Appeal Decision

Appeal Ref: APP/R5510/W/22/3309744

251 Long Lane, Hillingdon, Uxbridge UB10 9JP

- The appeal is made under section 78 of the Town and Country Planning Act 1990 against a refusal to grant planning permission.
 - The appeal is made by Arif Sheikh against the decision of London Borough of Hillingdon.
 - The application Ref 76753/APP/2021/3469, dated 13 September 2021, was refused by notice dated 29 April 2022.
 - The development proposed is Subdivision of plot and erection of 1 x 2 bed dwelling (Use Class C3), landscaping, and associated works.
-

1:200
Site Plan Proposed

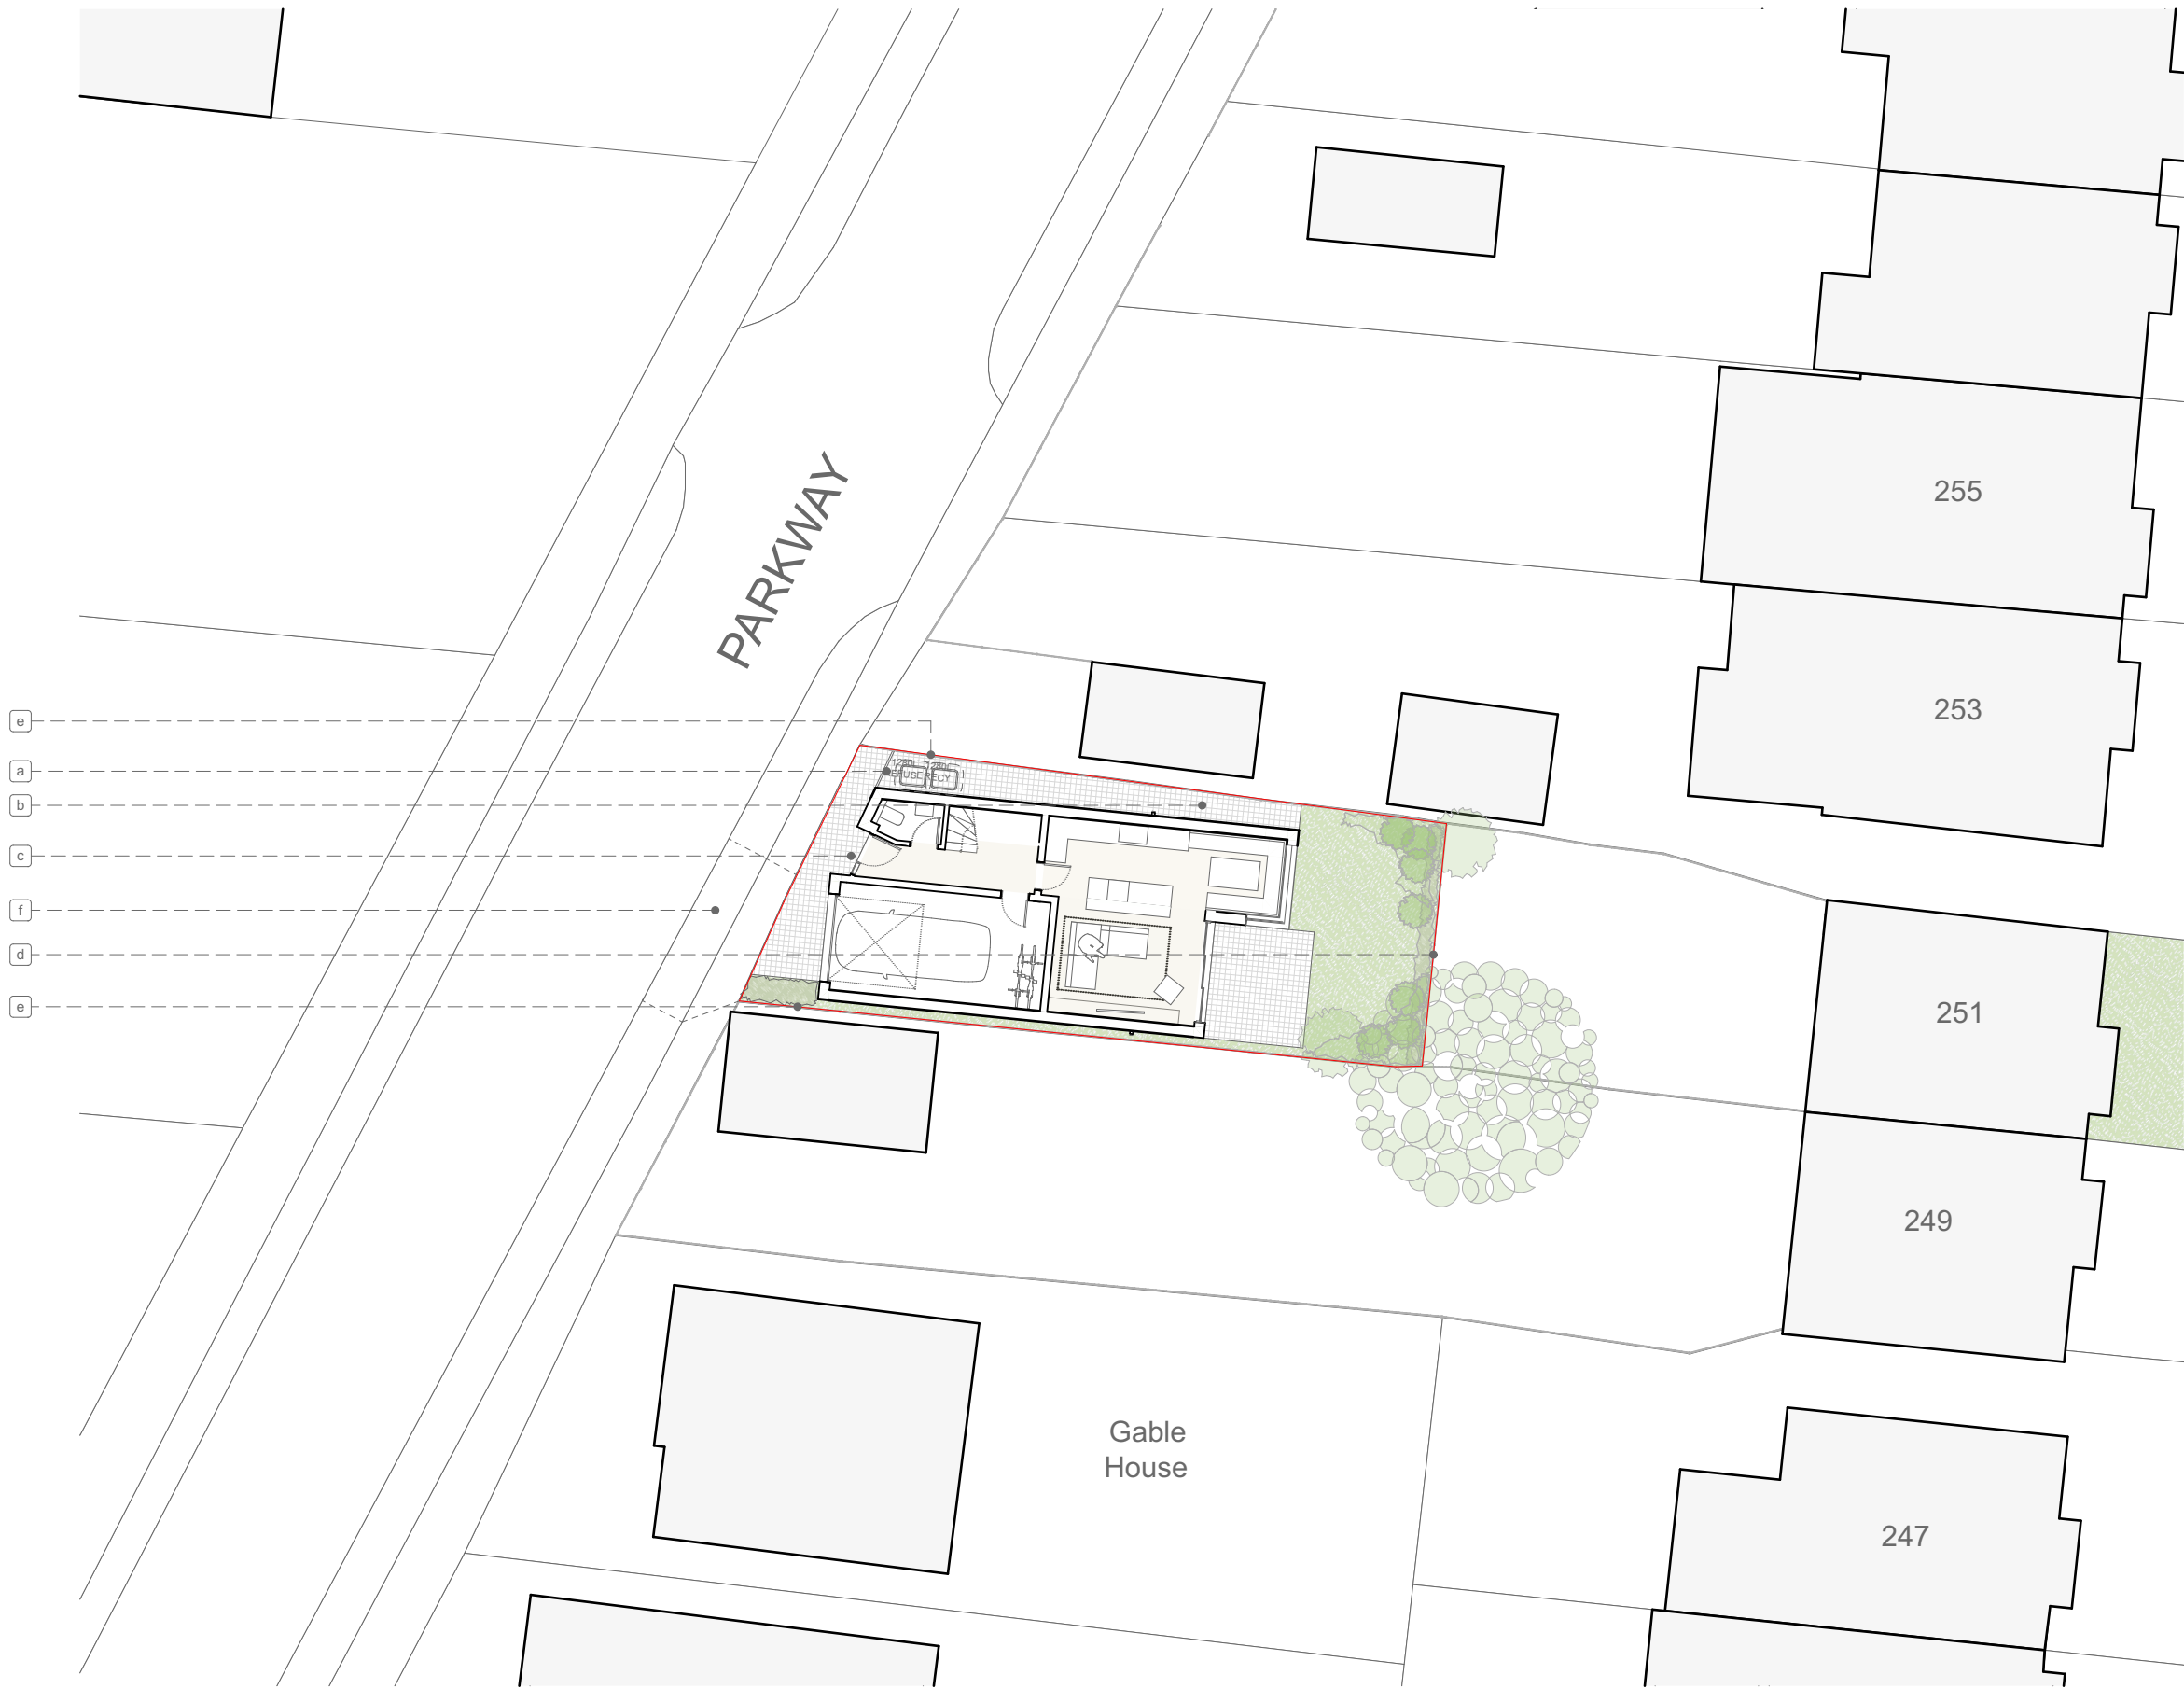
5. The proposal would most closely relate to the modern houses that have been built within rear gardens adjacent to the appeal site. This proposal would however differ from these as the plot size is visibly smaller. The proposed scale and massing would fill most of the width of the plot with built development and only a small pedestrian gap to one side of the house remaining. In addition, despite the proposed overhang, its set back from the front of the site would be very limited, further amplifying its bulk.

6. The proposed dwelling would appear cramped in its plot and out of character with the street scene where the layout of other plots are visually more spacious when compared to the appeal site, and the dwellings appear proportionately in scale to the size of the plot. This is taken together with greater private space surrounding others. This proposal would lead to detrimental visual intrusion to the character and appearance of the street scene.

1:100
Proposed Ground Floor Plan

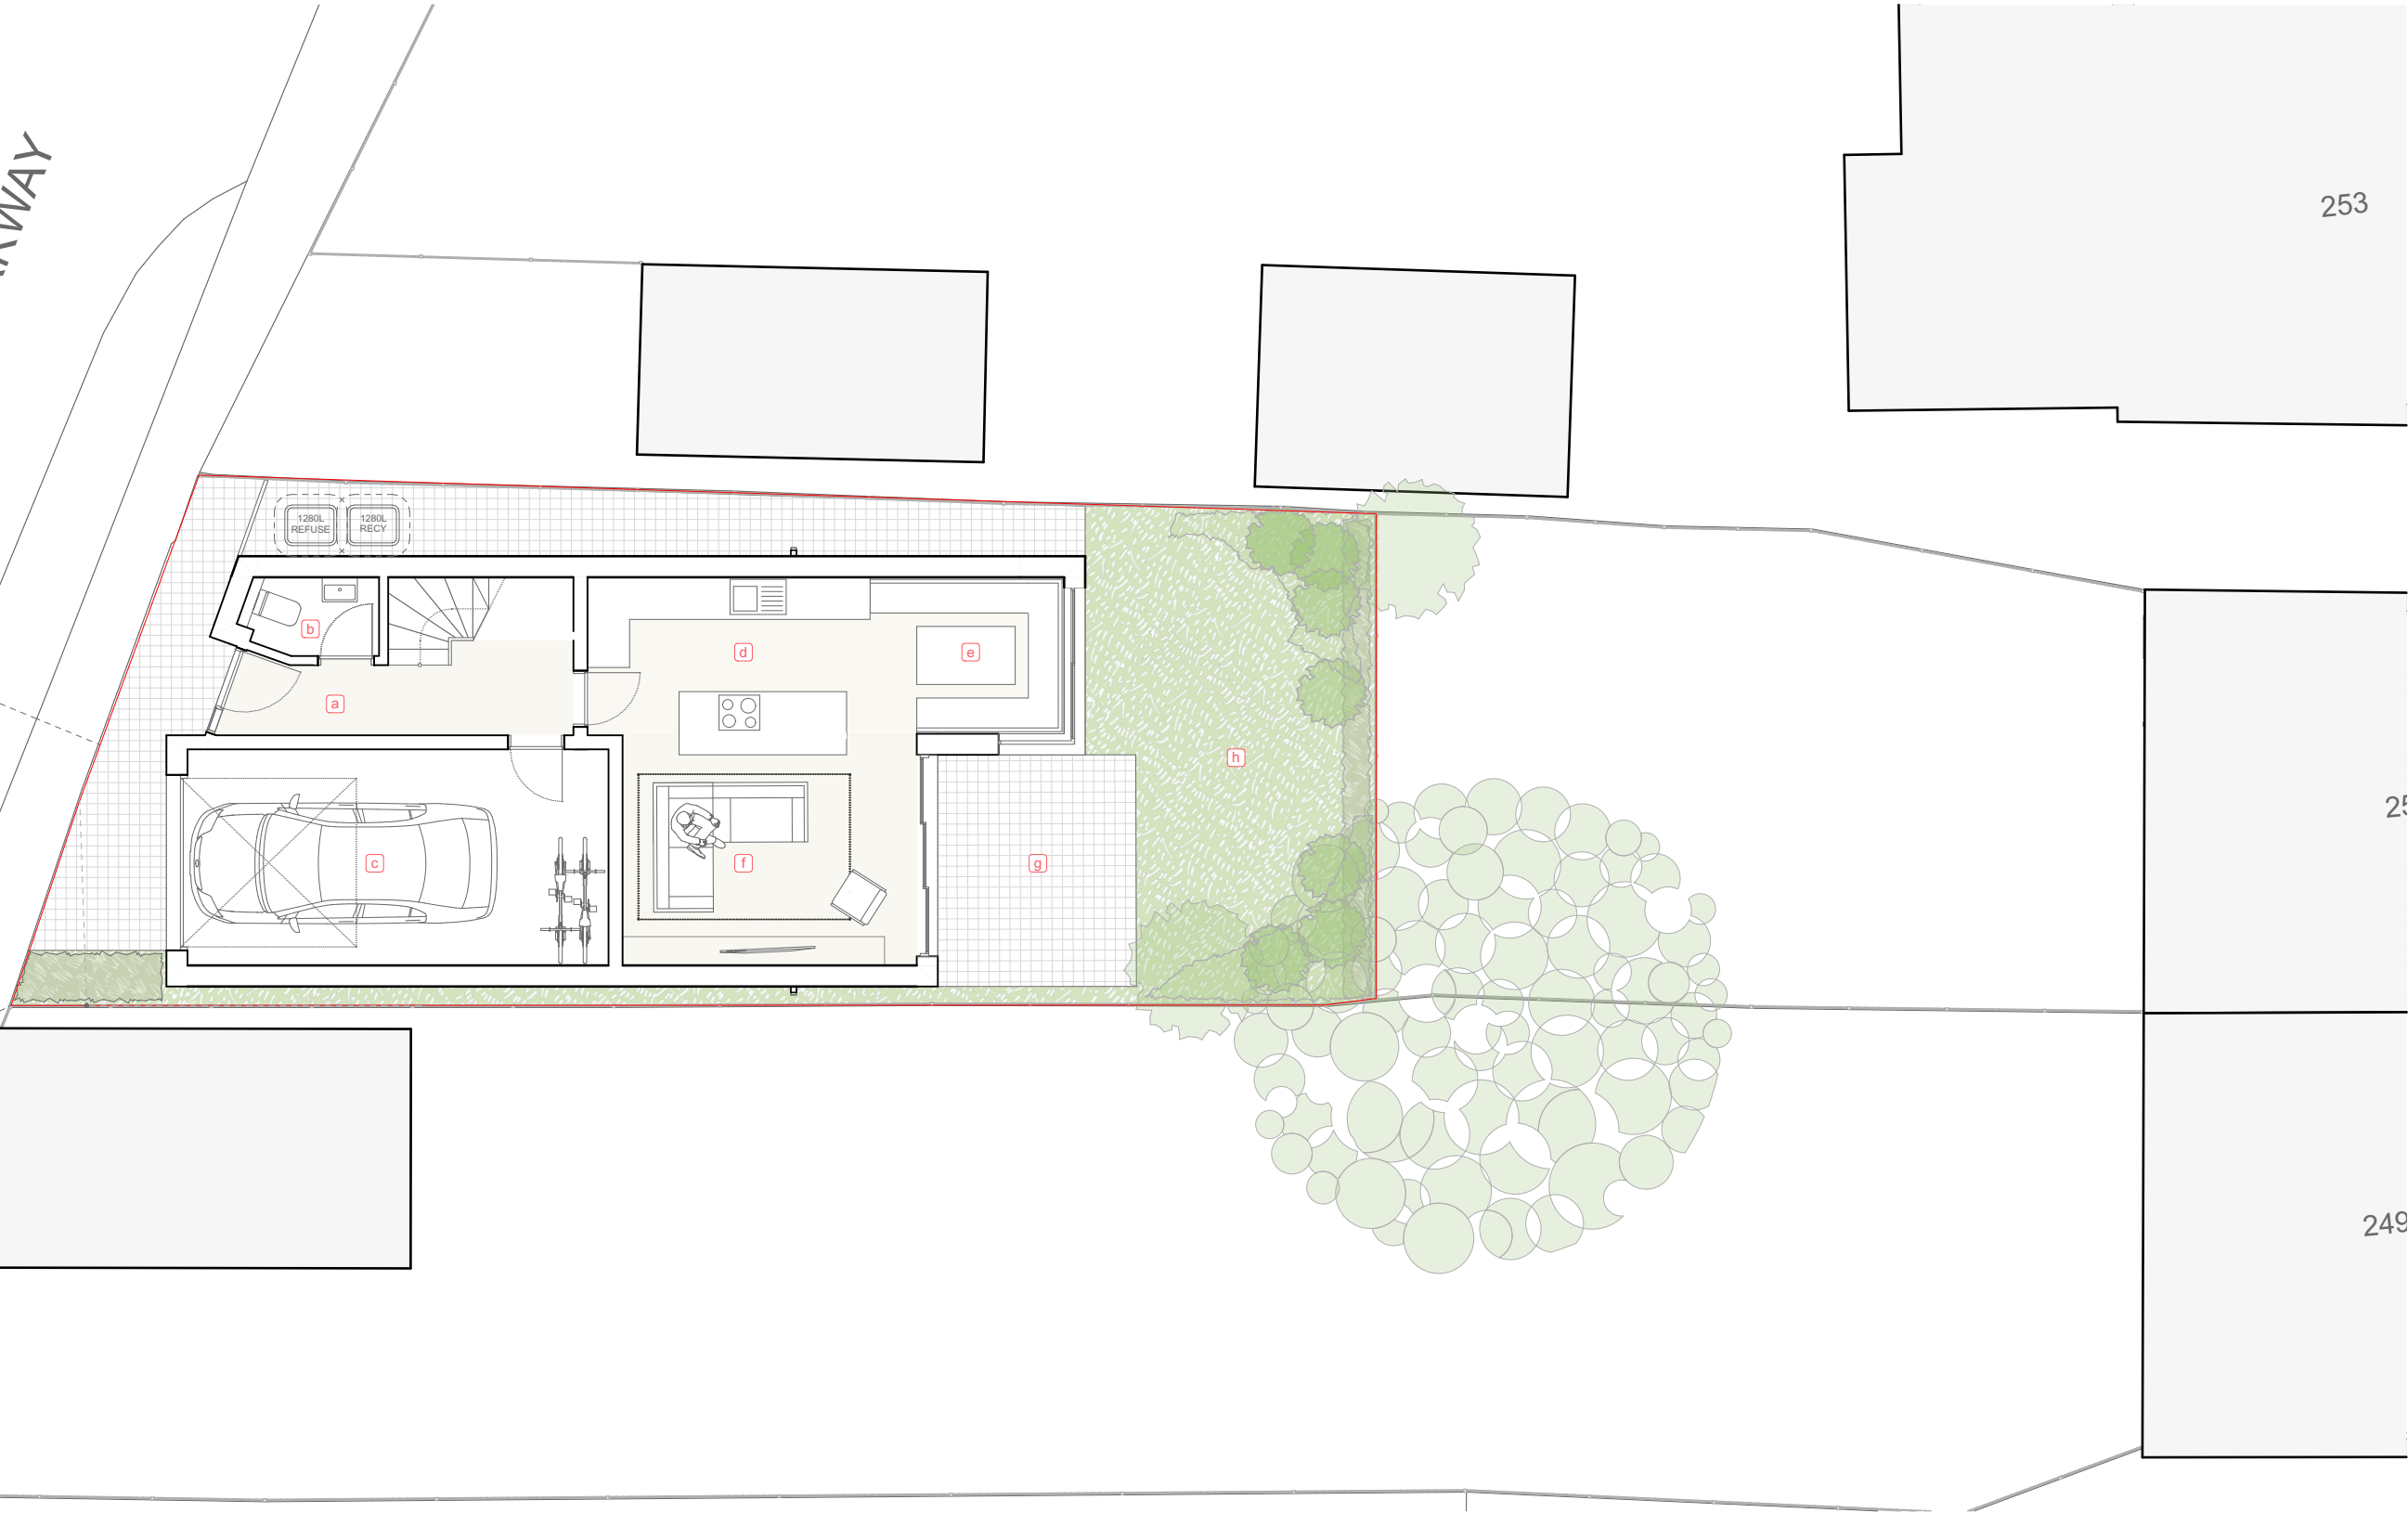
12. A garage currently provides on-site parking for No 251 with a dropped kerb to Parkway. An integral garage would provide parking for the appeal proposal. The existing garage is positioned at an angle to the road. This alignment does not appear to be significantly different to the arrangement as existing, or to that of other houses I viewed on site.
13. Therefore, I find no discernible difference that would lead me to conclude that the proposal would lead to danger to both pedestrians and the highway. The scheme would therefore comply with Policy DMT2 and DMT6 of the Hillingdon Local Plan (2020) and Policy T6 of the London Plan (2021) in their parking standards and highway safety objectives.

1:100
Proposed Site Section

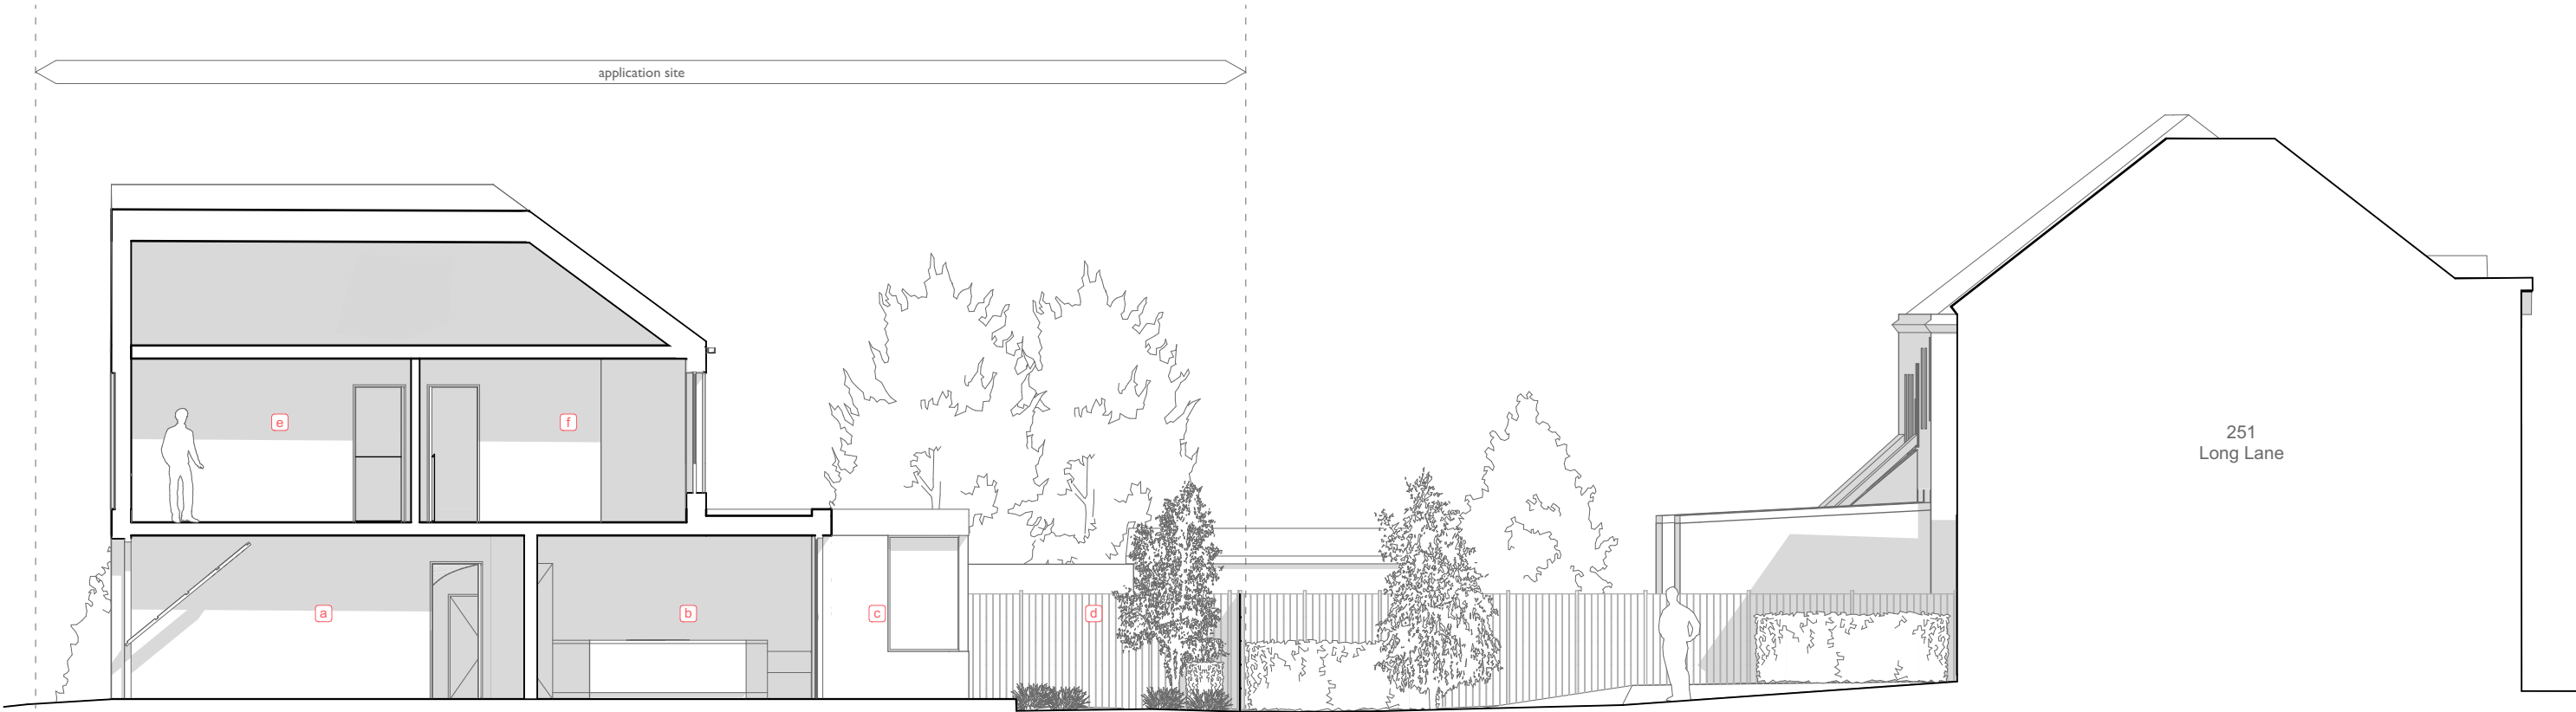
8. The separation distance between the rear elevation of Number 251 and that of the first floor of the proposal would not meet the desired level set out by the Council at approximately twenty-one metres. Overlooking would therefore occur between the two dwellings with No 251's rear facing bedroom window and the first floor rear window serving a bedroom of the proposal. These rooms are habitable rooms and despite the appellant pointing me to the Mayoral Housing Guide relating to minimum standards, given the relationship between the two, it would negatively affect the living conditions of both occupants.

9. Therefore, as a result of the scale of the proposal and the shorter separation distance from these windows, overlooking and a loss of privacy would occur between dwellings. This would result in failing to safeguard the living conditions for both future occupants and those of the existing dwelling.
